A19 Downhill Lane Junction Improvement

Scheme Number: TR010024

6.3 Environmental Statement – Volume 3: Appendices

APPENDIX 1.1 PINS SCOPING OPINION RESPONSES LOG

**FIGURE 2.4**

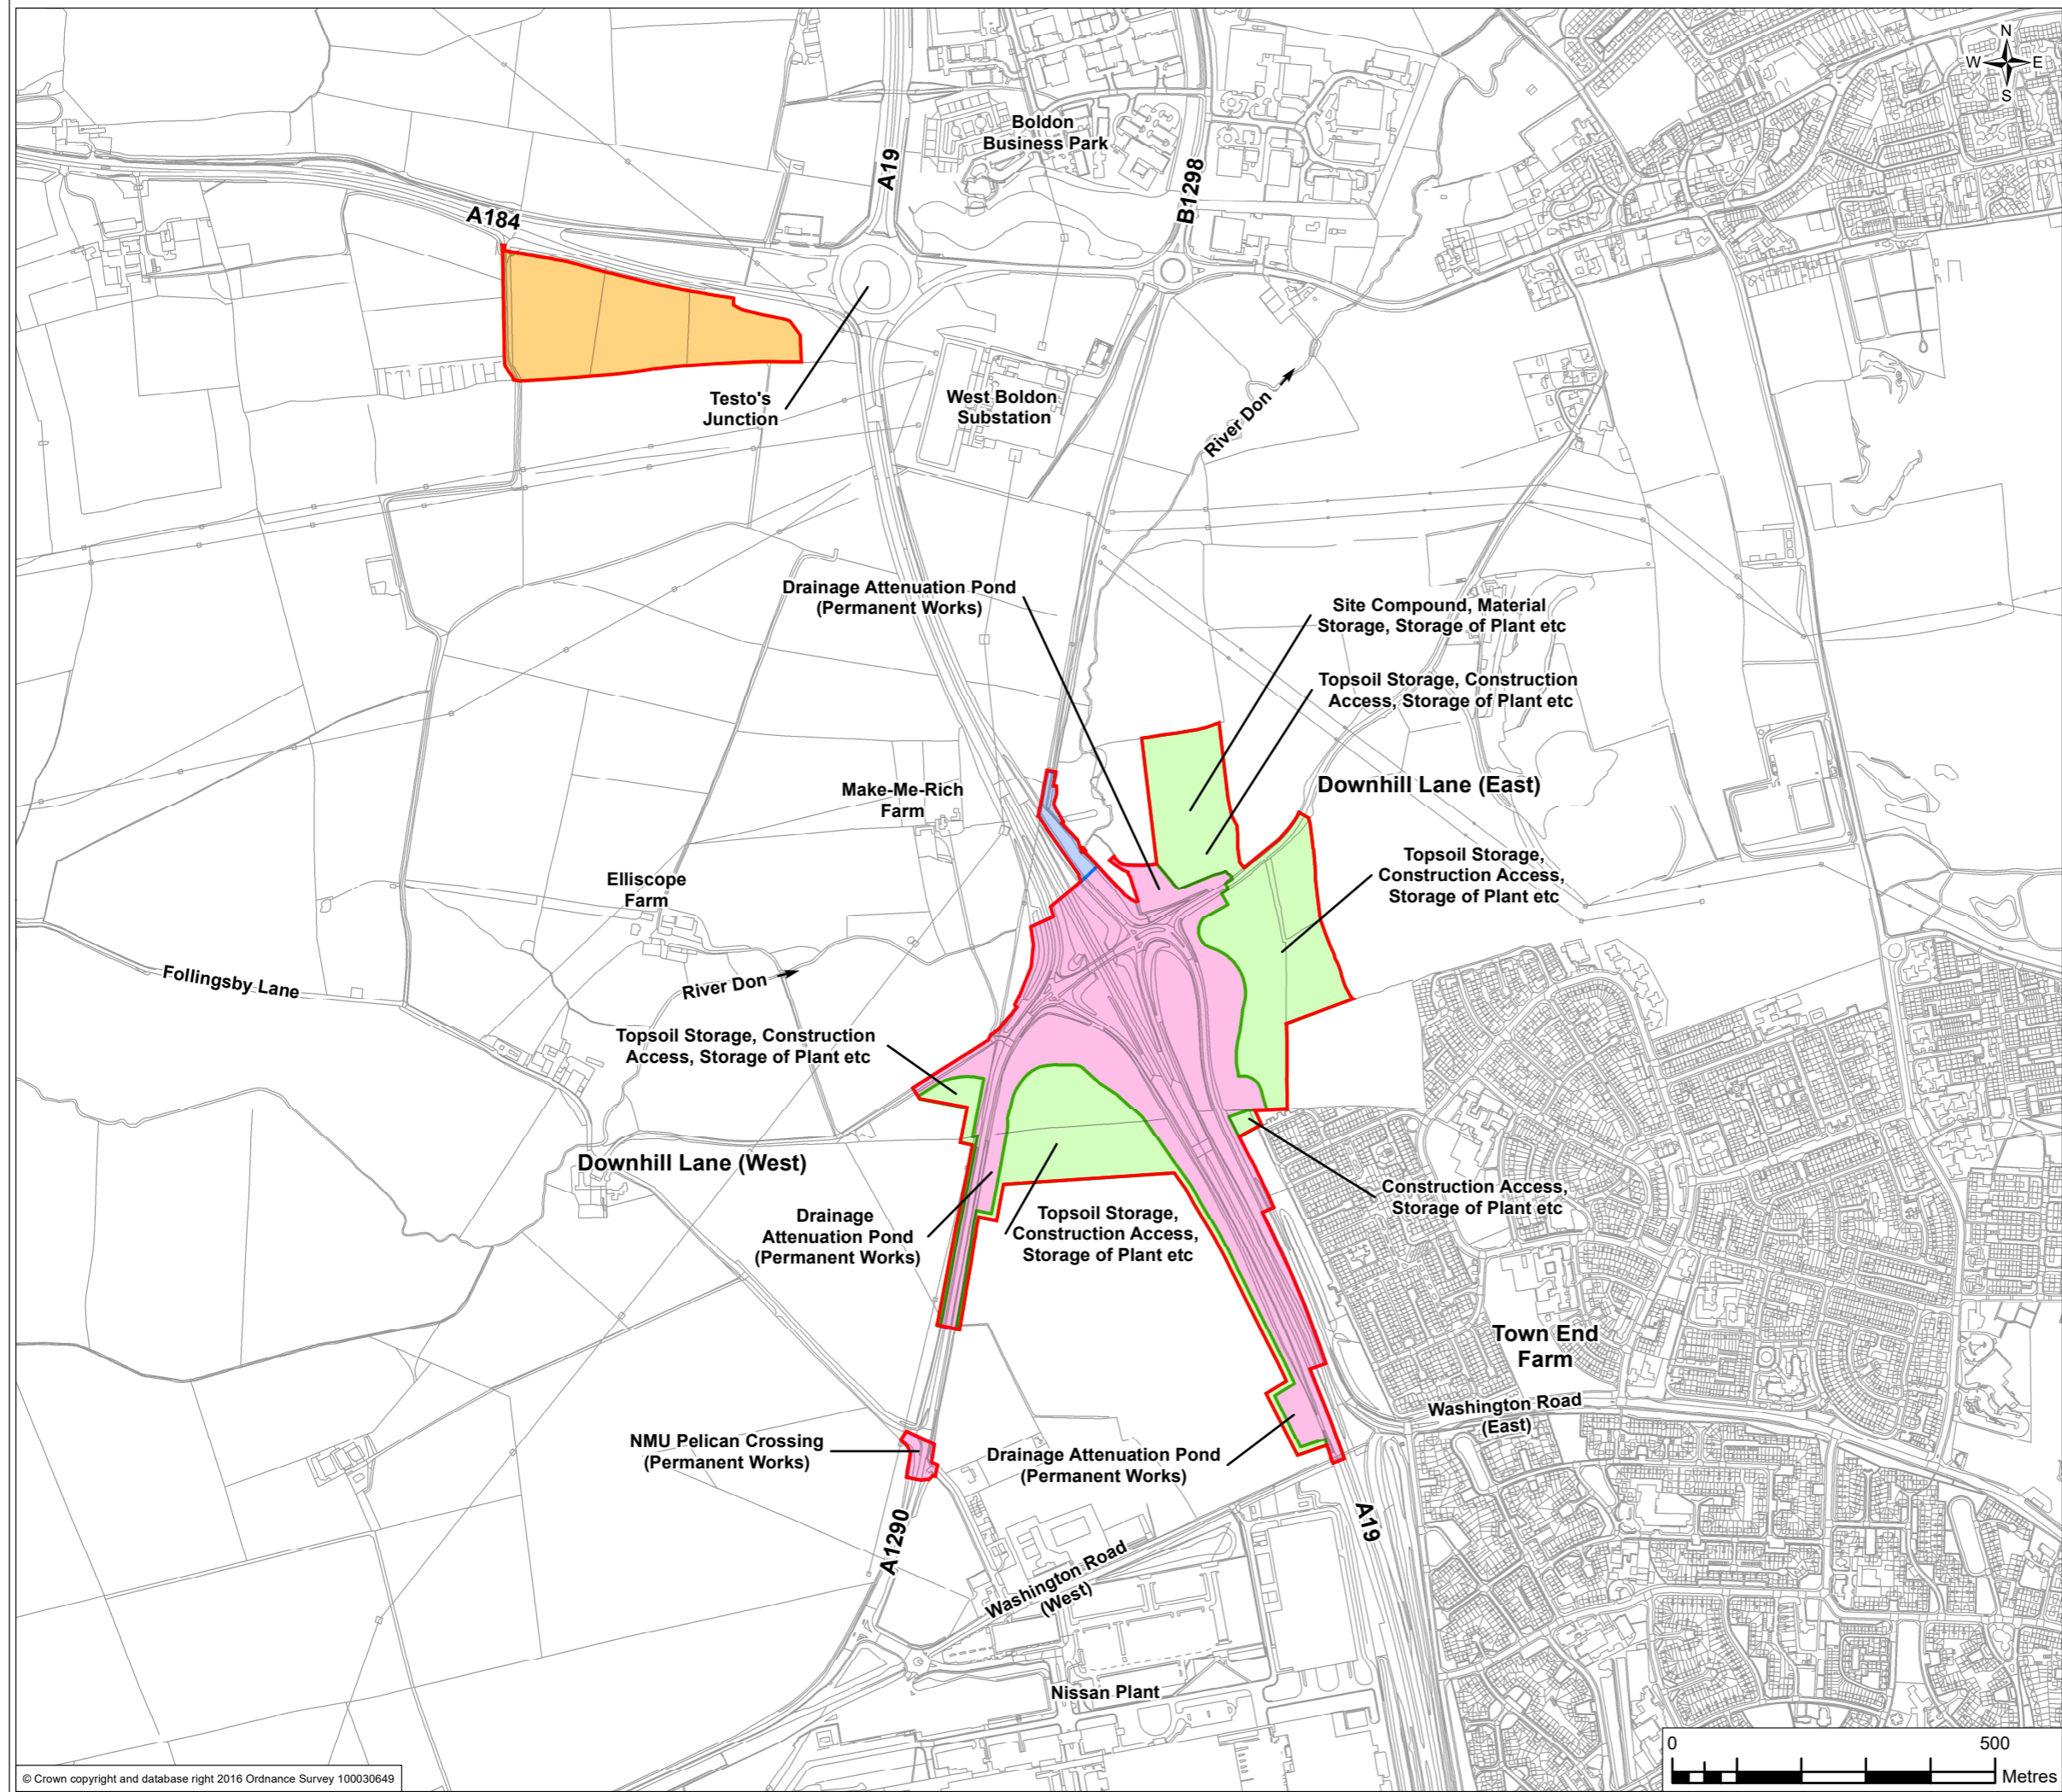
10	Construction and Access	2.57	Include information regarding the size and location of construction compounds in the DCO boundary.	Y	The location of the main site compound is shown on Figure 2.4 in Volume 2 (Figures) of the ES. This does not outline the size of the compound specifically as it remains to be confirmed subject to realising the opportunity to share the Testo's main site compound. However, the figure shows the area of temporary land take set aside for material storage and the main site compound. The land shown represents the worst case land take.
11	Construction and Access	2.58	Information on construction including: phasing of programme; construction methods and activities associated with each phase; siting of construction compounds (on and off site); lighting equipment/ requirements; and number, movements and parking of construction vehicles (both HGVs and staff) should be clearly indicated in the ES.	Y	An outline programme is included, showing high level phases and an overview of activities within each phase. High level outline information on the haul roads and their anticipated routes and construction method, plus information on lighting and the location of the main site compound, have been provided with sufficient detail to inform the development of the ES; although the exact main site compound layout, in terms of parking areas etc., would be further refined during detailed design.

**FIGURE 6.1**

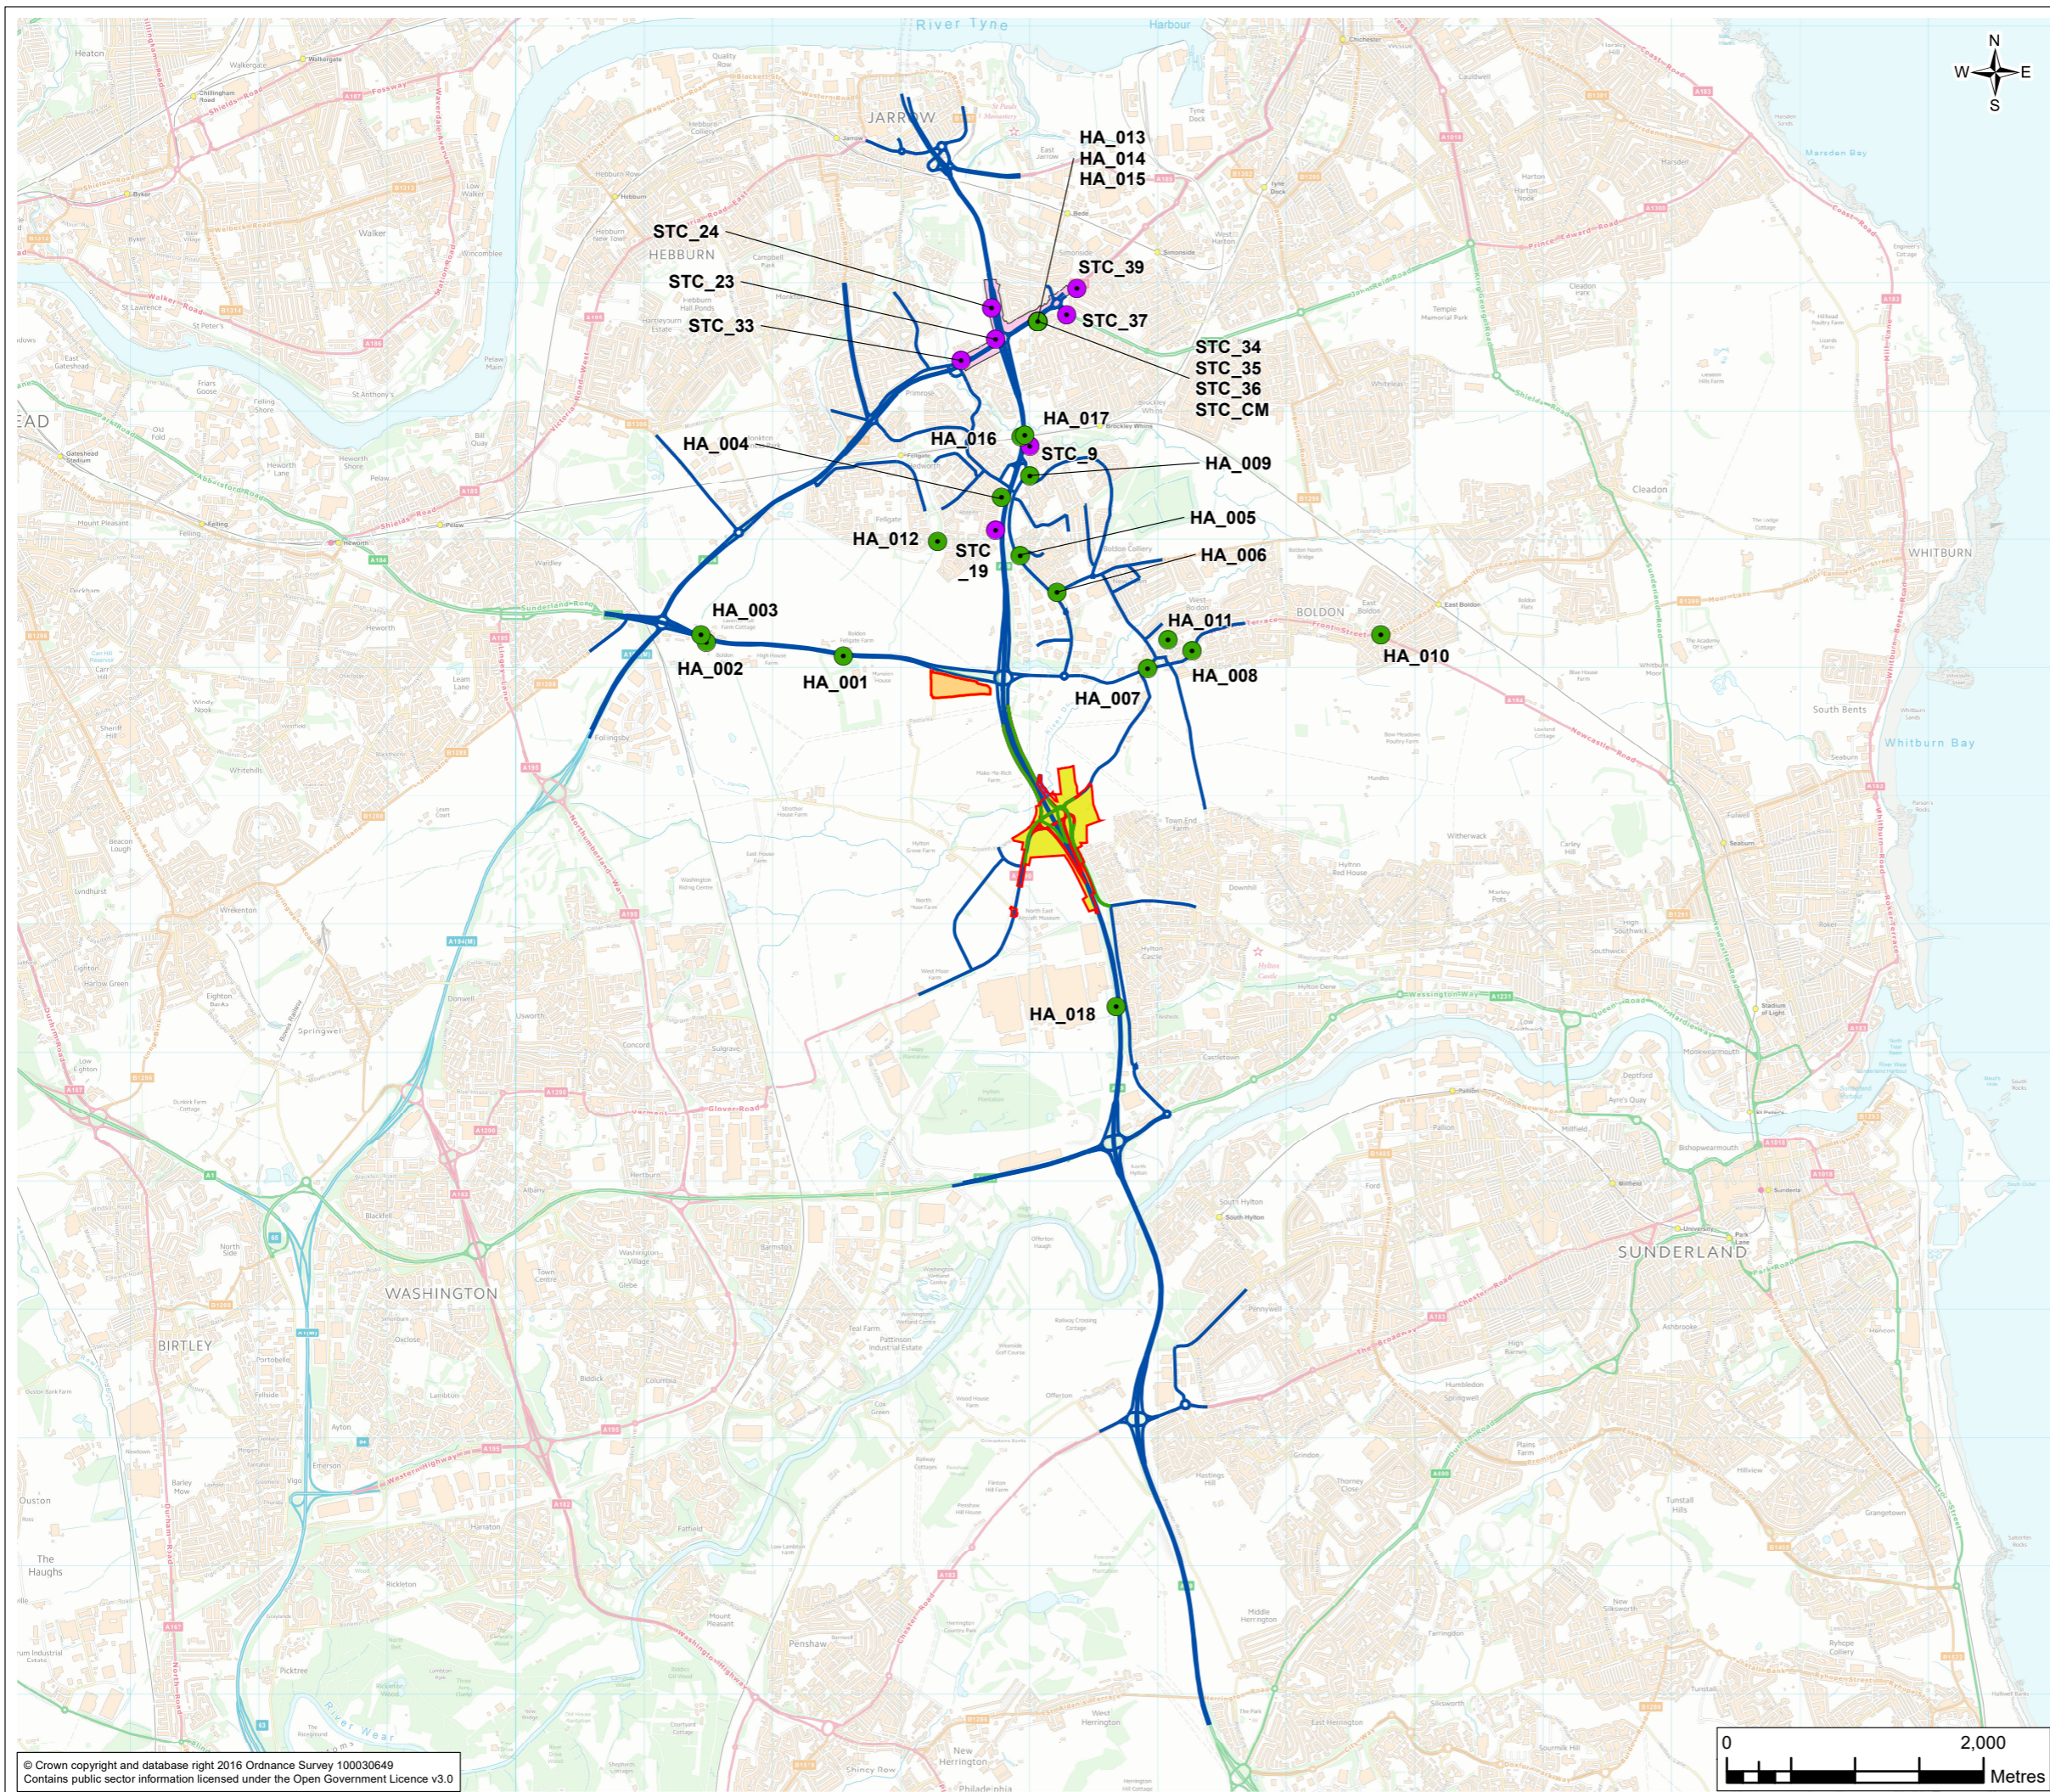
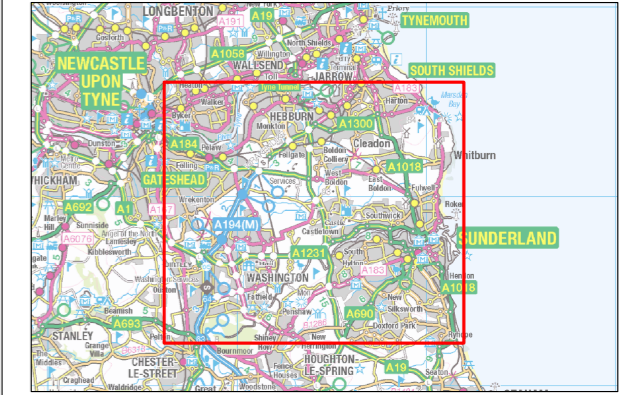
41	Air Quality - Figures	3.32	Present a clear figure of the affected road network as well as figures showing other sensitive receptor locations identified for the purposes of the air quality assessment.	Y	Figure 6.1, in Volume 2 (Figures) of the ES, outlines the affected road network and any sensitive receptors.
42	Air Quality - Inter-relationships	3.33	Consider and assess the inter-relationship between air quality and ecological impacts with cross reference to other relevant chapters.	Y	Inter-relationships are considered at the end of each specialist chapter (Chapters 6-14) of the ES.
43	Air Quality - Further Assessment	3.34	Given that the affected road network has yet to be fully defined, the SoS cannot agree that potential air quality effects of the Proposed Development do not require further assessment at this stage as it is not possible to know with certainty whether anticipated effects will or will not occur for given receptors. The need for further assessment should be explained and justified in the context of the affected road network once it has been defined.	Y	This has been included within Chapter 6 of the ES.
